Planning Application Ref: AB/9/14/TC

Location : Garden r/o 6 Bakers Hill Road, Arundel

Description of works: ***This is linked to a recent Planning Application***

Site Plan Trees
Scale 1:100

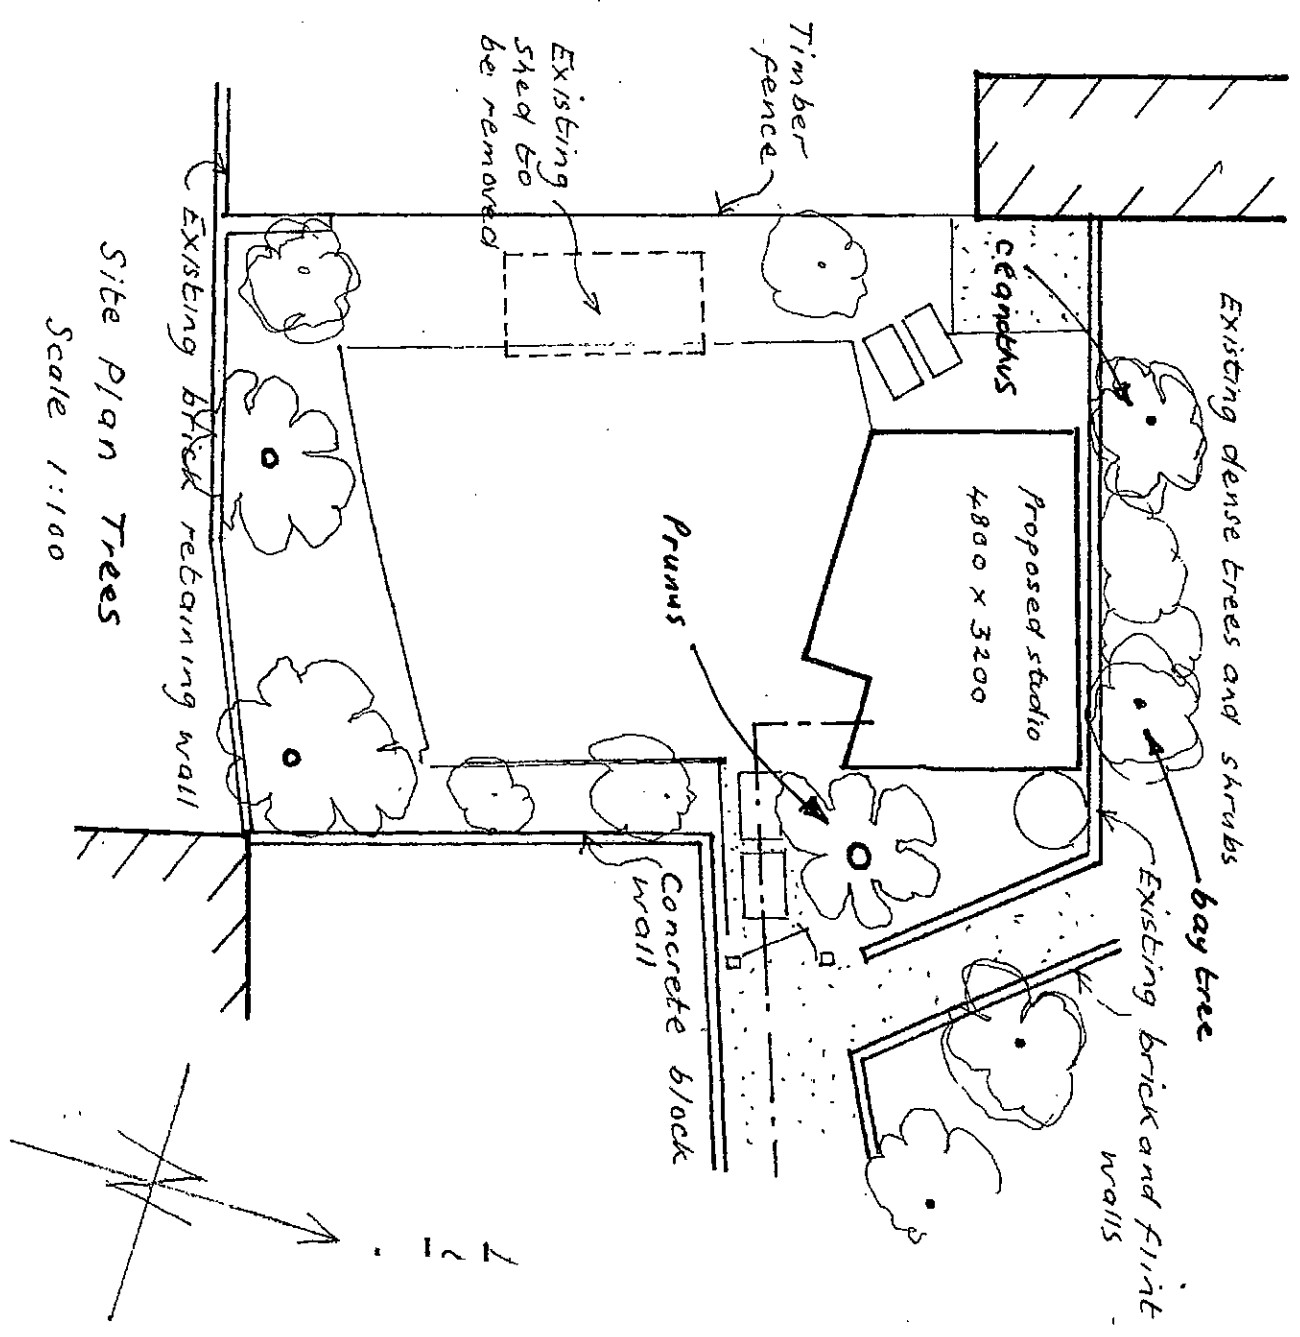
- An open and low spreading form due in part to previous pruning operations – has been reduced and reshaped with approximately 0.5m of regrowth arising from old pruning points.
- Has also been crown lifted to 3m above ground level in the past.
- Bifurcated at 1.8m and has a low spreading ‘umbrella’ form.
- The proposal is to shorten back the lowest branch on the west side of the tree by approximately 1m back to a living growth point. She has agreed to wait until the tree has finished flowering.

- Both plants are growing in the neighbours garden to the north side of the boundary wall but most of their crowns are presented overhanging the boundary line into the garden of No6.
- Some stems are resting on the top of the wall causing it to crack and in the case of the Bay the expansion of the stems is cracking the boundary wall – not sure who owns it?

- **I raise no objection** to the pruning works.
- I recommend that when considering the planning application for the Studio that the pressure to prune the Cherry is taken into account and the location of the Studio is moved further across to the west.
